**Our Case Number:** ACP-323742-25

**Re:** Proposed development comprises the development of an extension to the existing Burial Ground at Drumcliff Burial Ground located at the Townland of Drumcliff, Ennis, Co. Clare

Case Ref: JP03.323742

Submission on application by Clare County Council for Burial Ground Extension at  
Drumcliff, Ennis, Co. Clare.

Proposed Soakpit No.1 Location
225m² x 3m deep
Invert 1m below ground

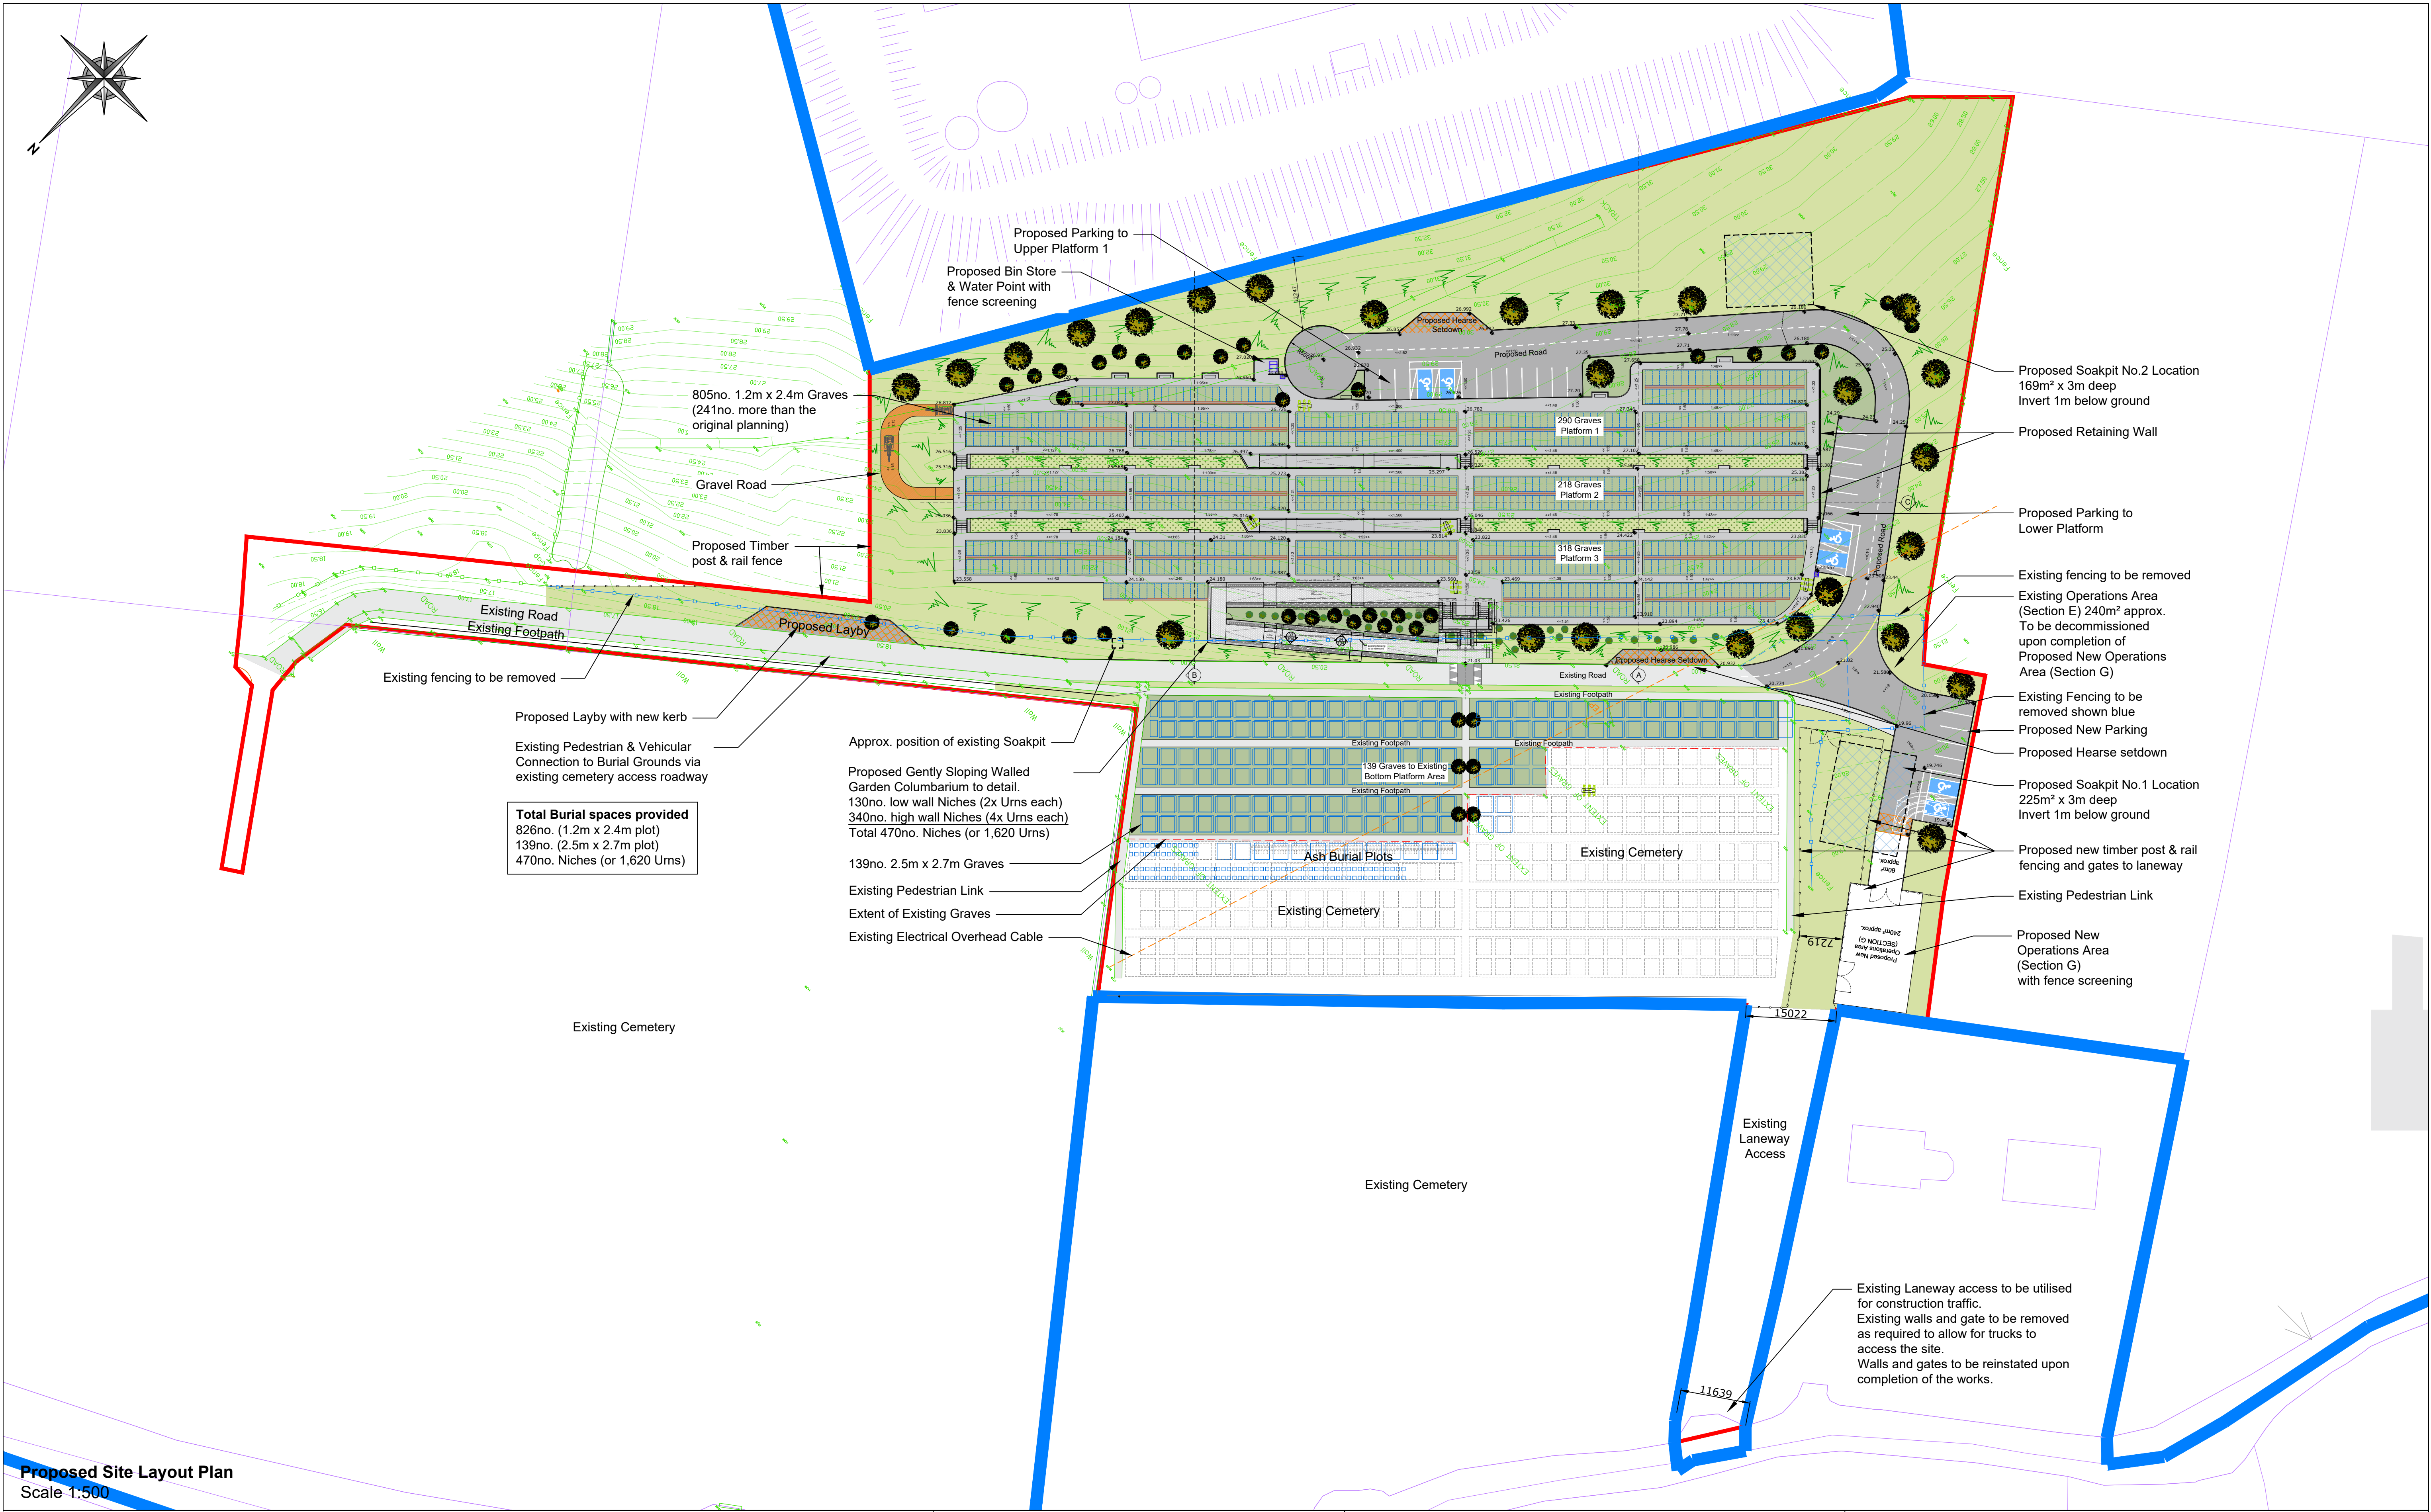
I must state that I am not against the proposed development in any way and I appreciate from viewing proposed design drawings , that Clare County Council are trying their utmost to facilitate concerns re: flooding. I note the inclusion of two new soakpits but would still have worries about its capacity to cater for the sheer volume of storm water etc as our weather systems are now producing wetter and wetter seasons.

CLIENT: Clare County Council
TITLE: Watermain & Storm Water Sewer Layout

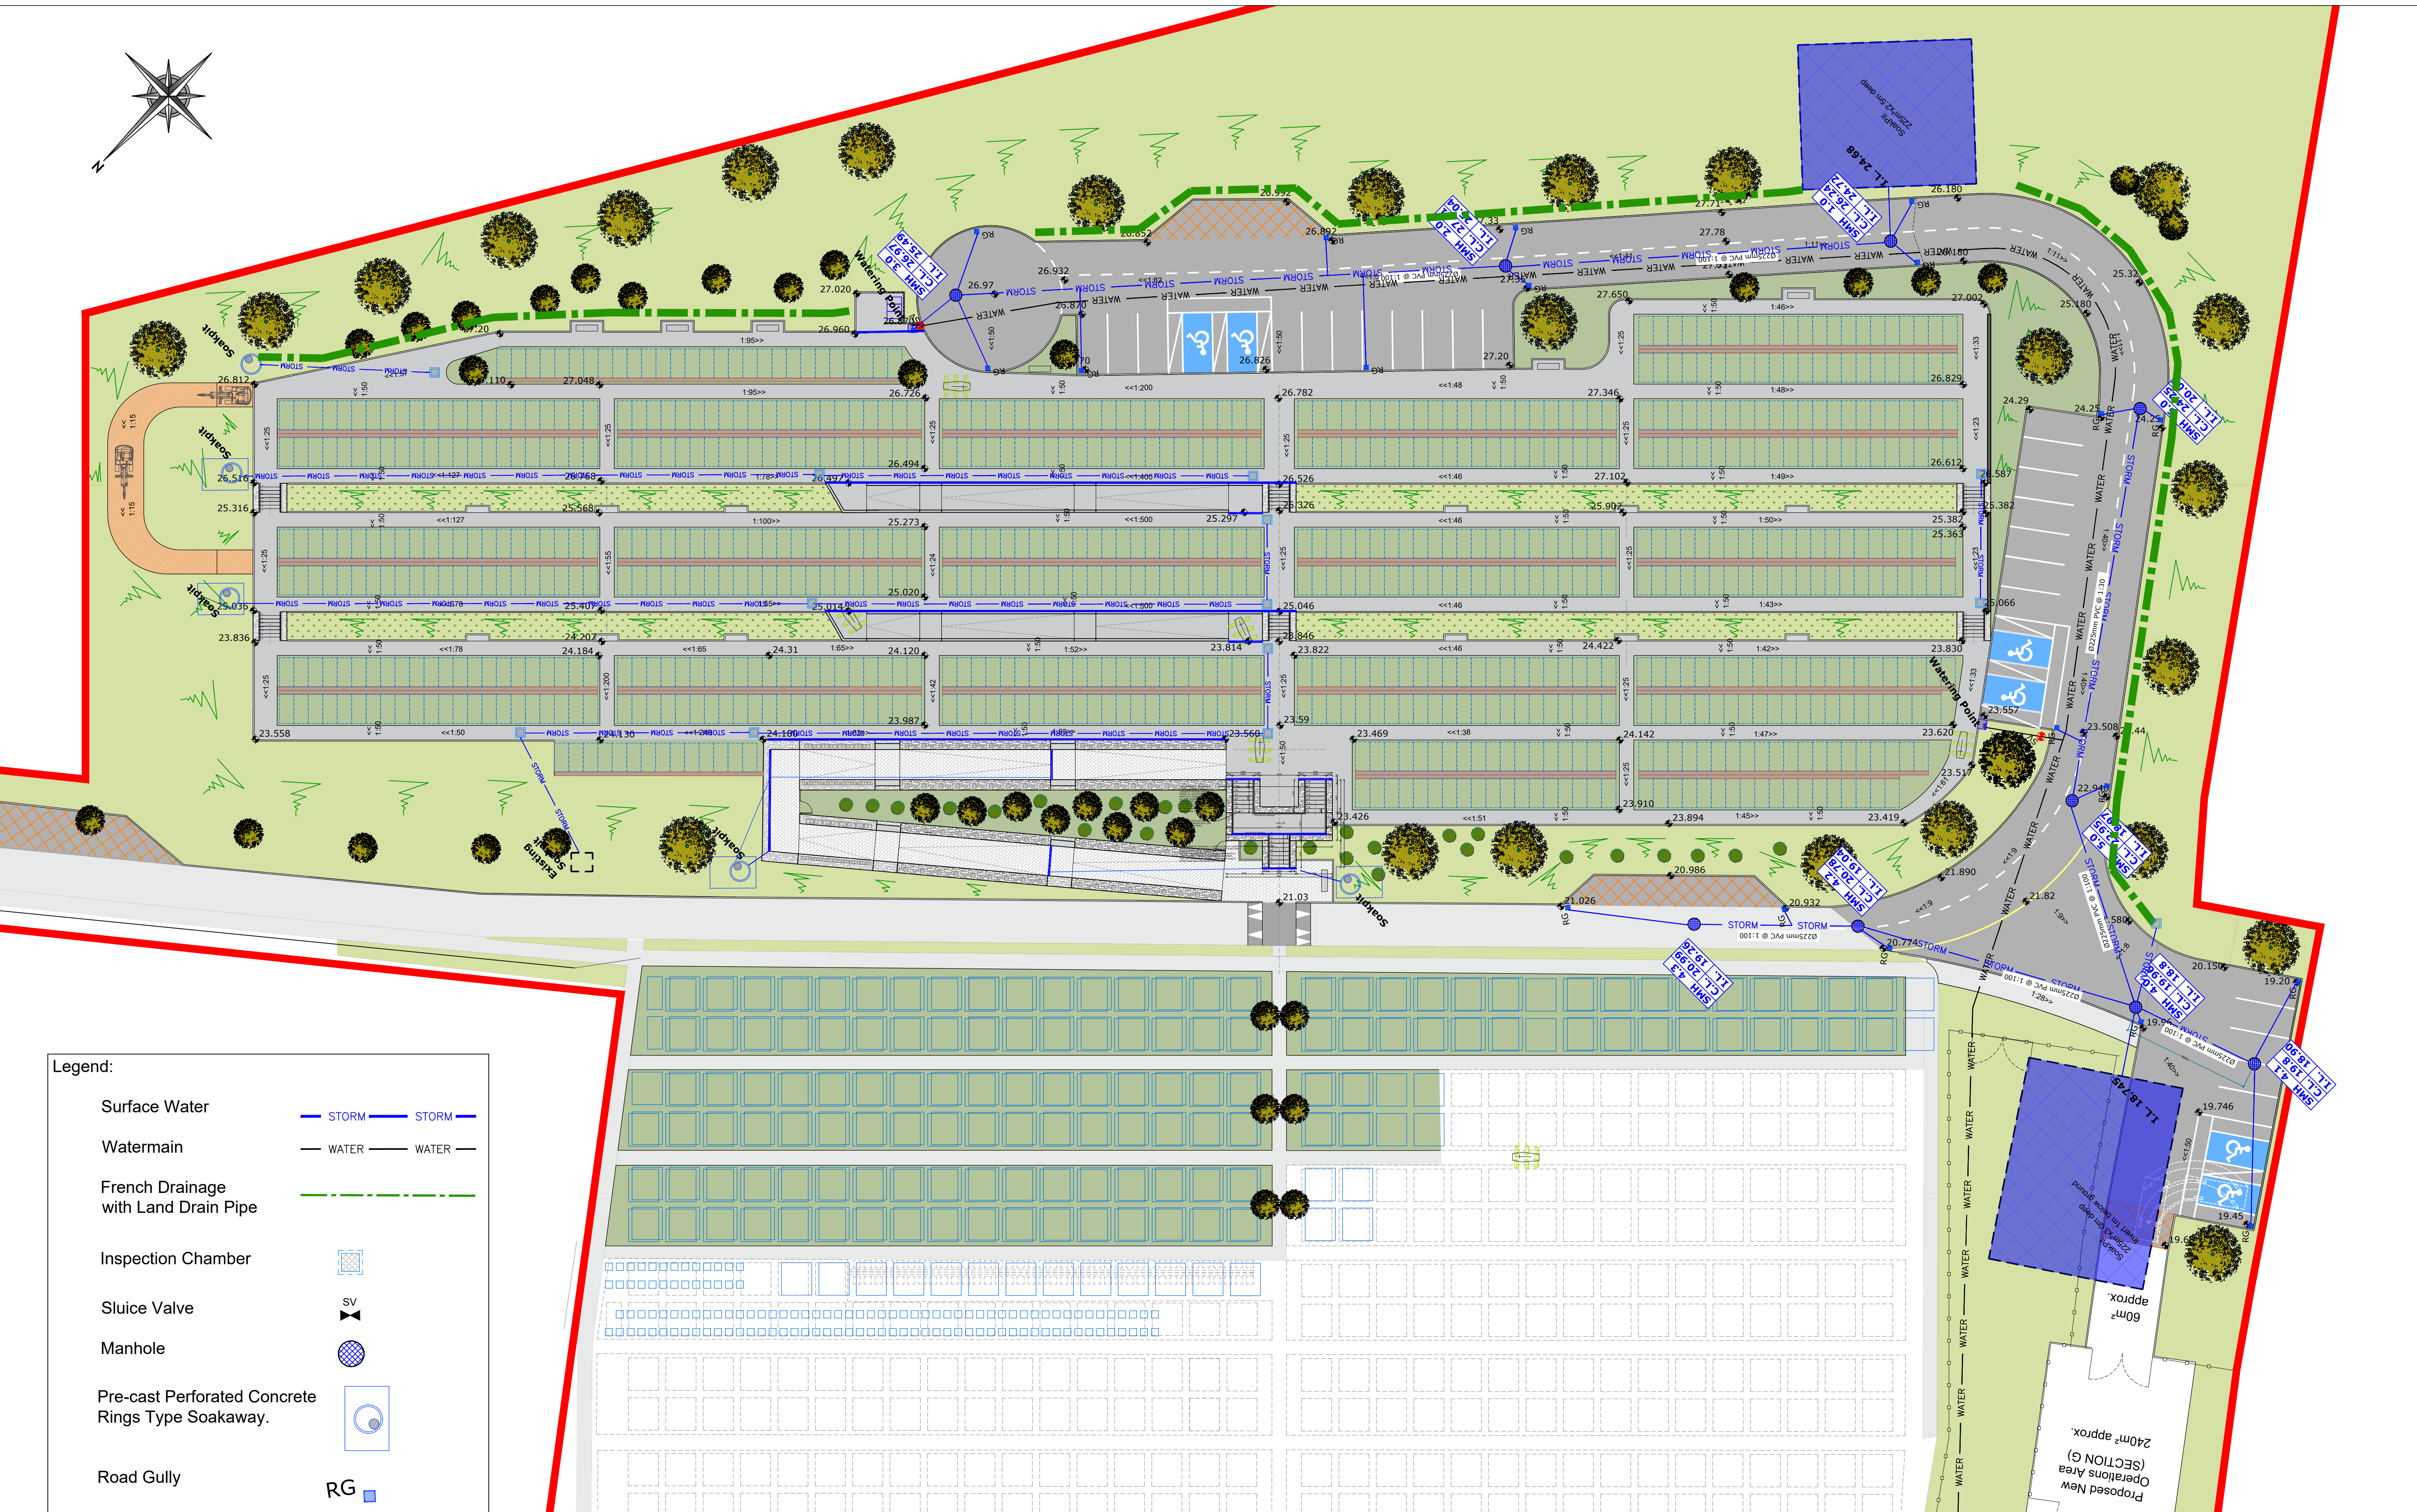
There has been various ongoing works at the graveyard over a number of years be it landscaping/improvements/drainage etc and this has lead to hereto unknown flooding issues mainly to public road that has directly affected my property. I am fearful that if this issue is not resolved it may lead to flooding of my dwelling and public road adjacent with associated traffic safety concerns.
